**PLANNING AND COMMUNITY DEVELOPMENT**  
CRAIG DOSSEY, EXECUTIVE DIRECTOR

2/20/18

Subject: Academy Gateway 7-11 Site Development Plan Review 2

**C2.2**  
SHEET 5 OF 16

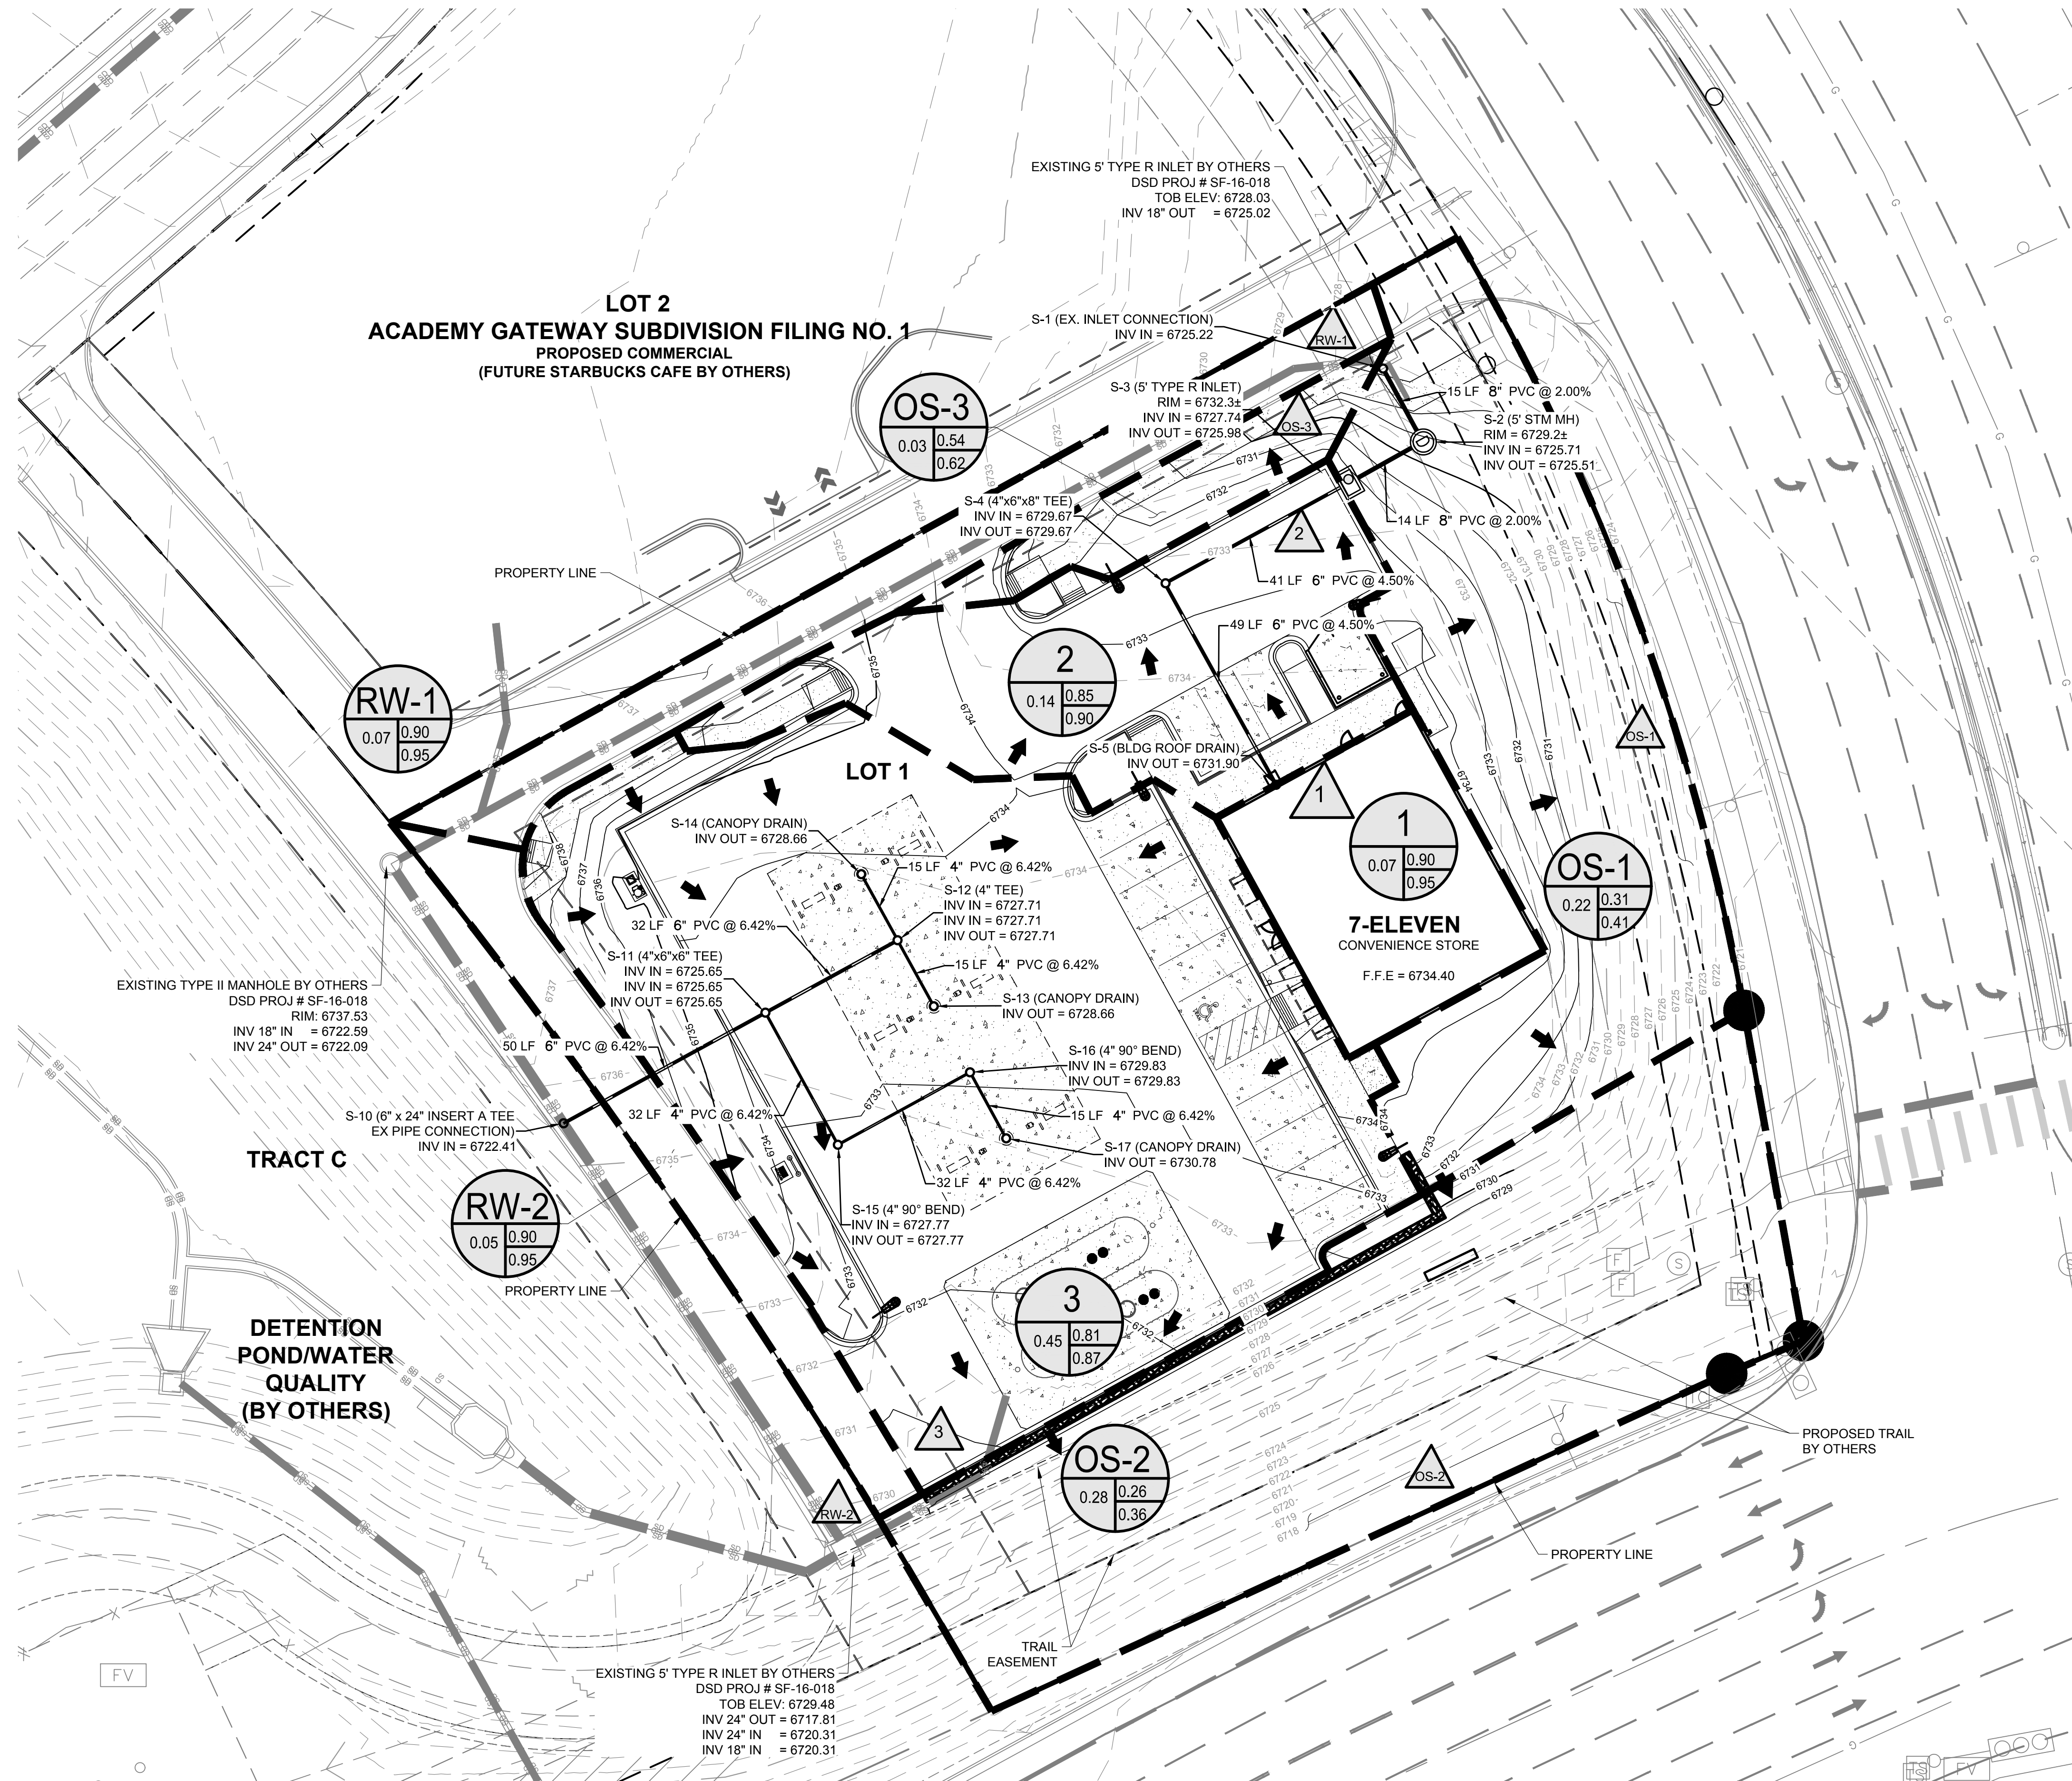
1. See redlines regarding WQCV and specialized BMPs. Note: the water quality portion of the Academy Gateway detention pond will need to be maintained for all lots in the subdivision. The anticipated downstream regional pond will not provide WQCV for this site. **Partially resolved, see updated redlines.**  
**Redlines addressed and notes added to report as requested.**
